CITY OF PORTLAND, MAINE

PLANNING BOARD

May 1, 2018

Project Name: Building Conversion
Address: 415 Cumberland Ave.
Applicant: Sam Reiche
Planner: Christian Roadman

EXISTING WINDOWS TO BE REFURBISHED WHERE POSSIBLE, AND WHERE NECESSARY TO BE REPLACED WITH NEW WINDOWS TO MATCH EXISTING (NEW WINDOWS WILL BE DOUBLE GLAZED BUT WILL MATCH IN APPEARANCE)

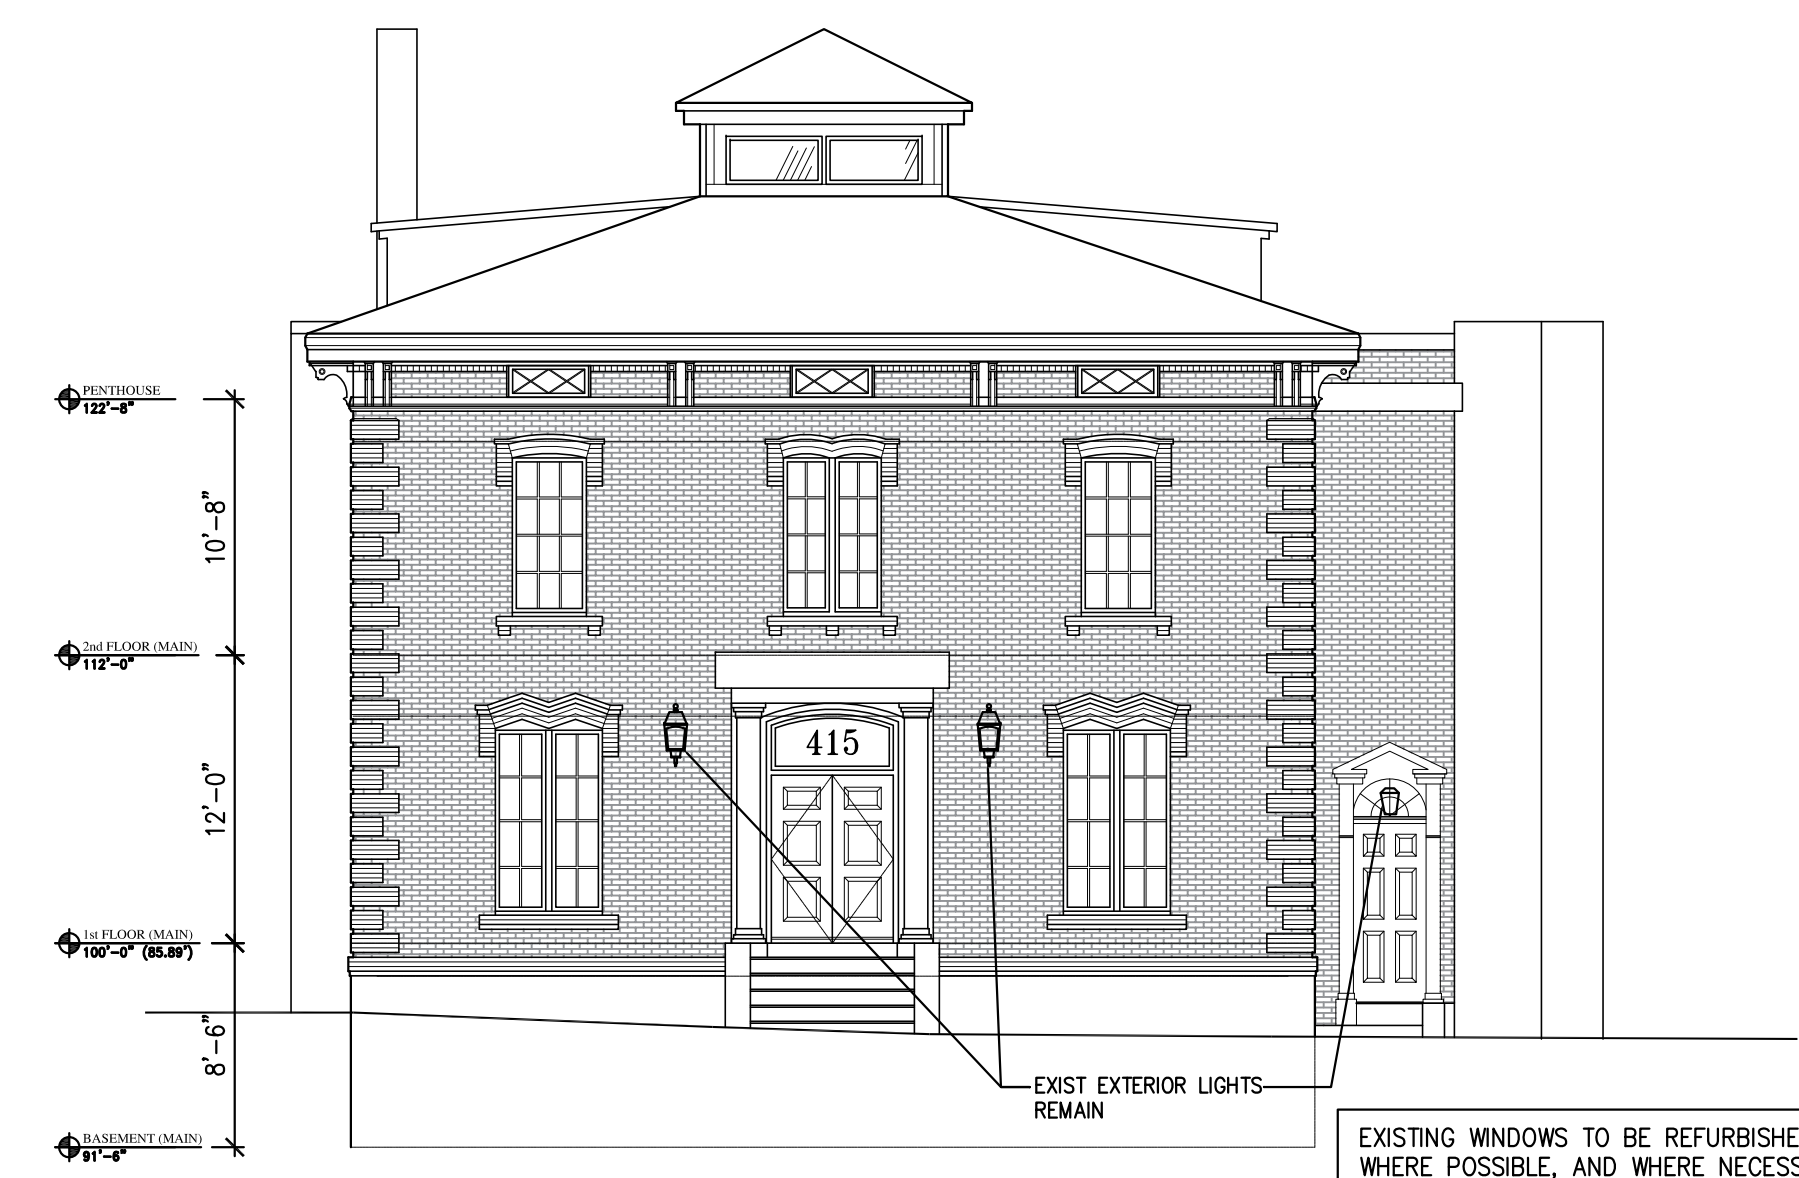
Ms. Andrews commented that new windows should match the existing windows in material, muntin configuration and profile, color, and operation. This is of particular importance on elevations in which new and existing windows will be present.

Additionally, Ms. Andrews requested a detail of the metal canopy proposed over the Forest Avenue entrance. Proposed window details, as well as the proposed metal canopy detail, should be submitted for review and approval by Ms. Andrews as a condition of approval.

1. Proposed window specifications and the proposed metal canopy detail shall be submitted for review and approval by historic preservation staff.
2. The applicant shall submit additional information pertaining to construction management, including:
 - Pedestrian detour plan minimizing sidewalk impact; construction material delivery and truck plan minimizing sidewalk and vehicle lane impact; and, information on contractor parking such that public on-street parking is not impacted.

GRAPHIC SCALE  
 ( IN FEET )  
 1 inch = 20 ft.  
**DEMOLITION PLAN**  
 SCALE: 1"=20'

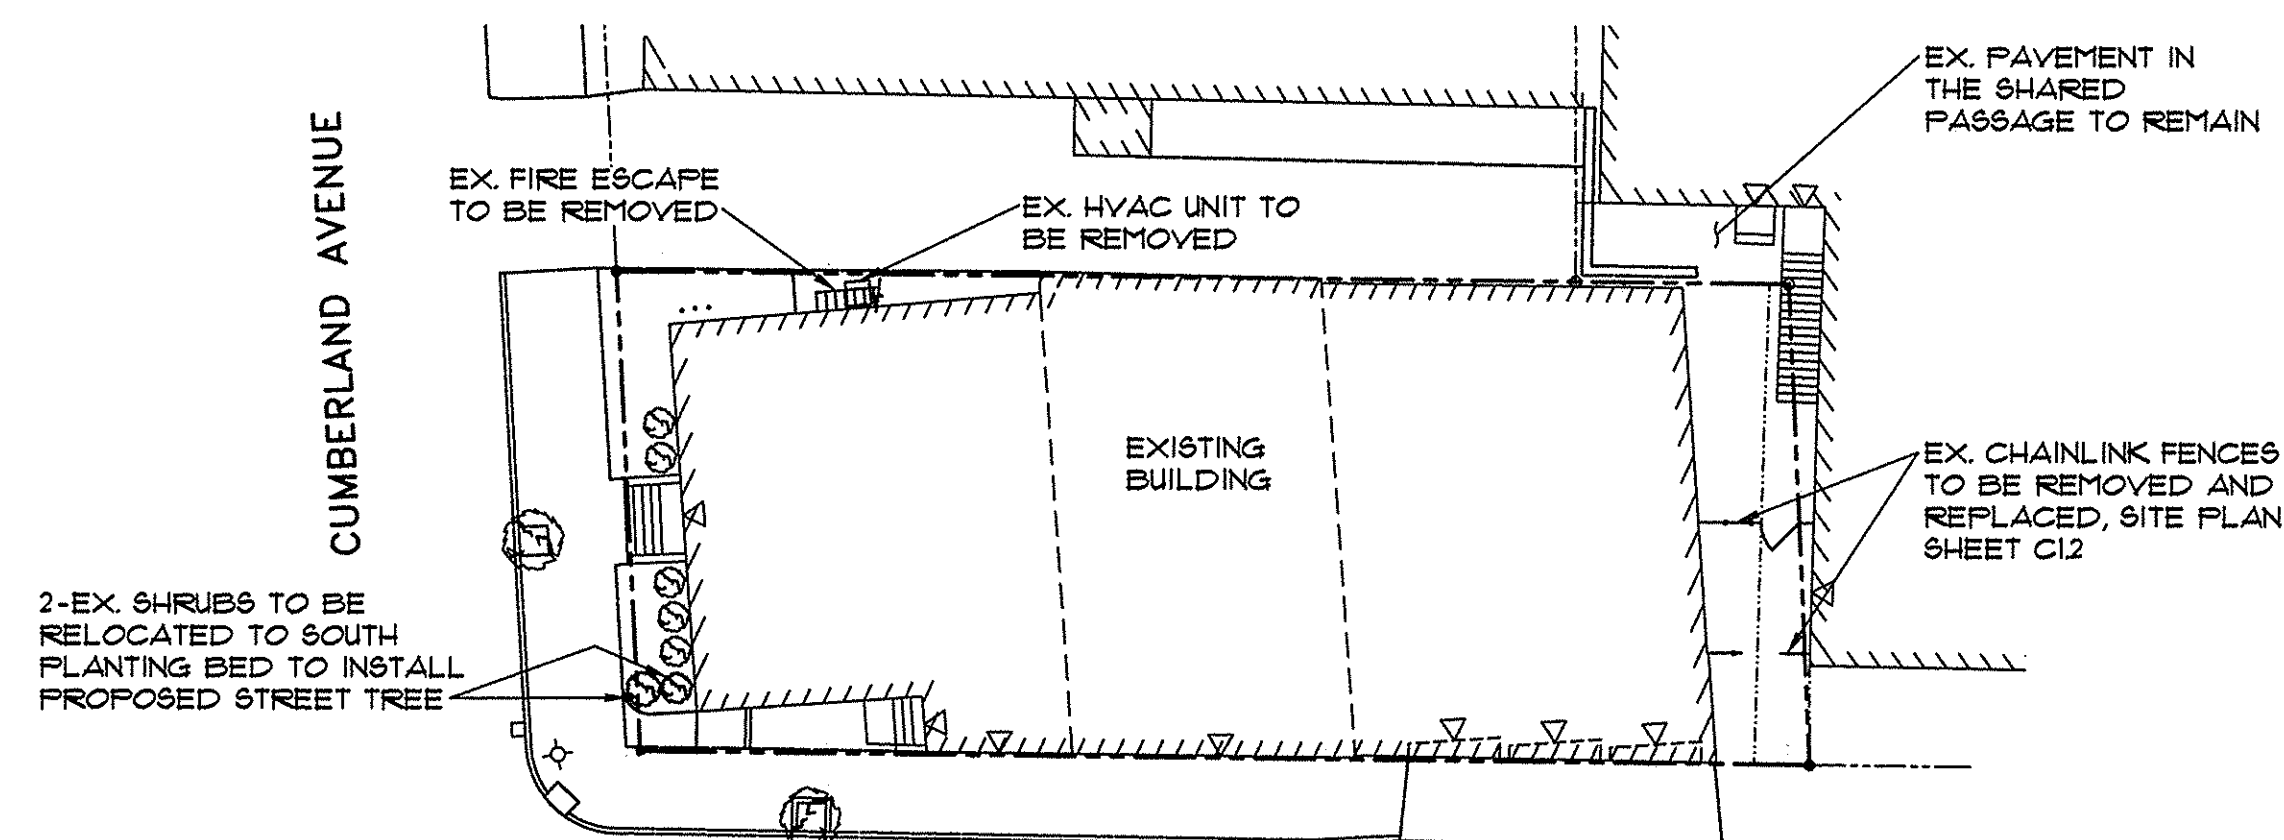
Bruce Hyman, the City’s transportation program manager, expressed concern regarding the condition and grade of the sidewalk and driveway along Forest Avenue. As a condition of approval, existing and proposed grades shall be submitted for review and approval by the Planning Authority.

3. The applicant shall submit for review by the Planning Authority and the Department of Public Works data documenting the condition of the existing sidewalk and driveway, including: physical condition; elevation changes (back of sidewalk and driveway to street); and, calculated cross-slopes (including any grade-breaks for specific widths). The applicant shall document that better or full ADA-compliance is or is not feasible. The Planning Authority and Department of Public Works may grant a partial waiver of the technical manual standards, if there are detailed data documenting that better or full compliance is not feasible.
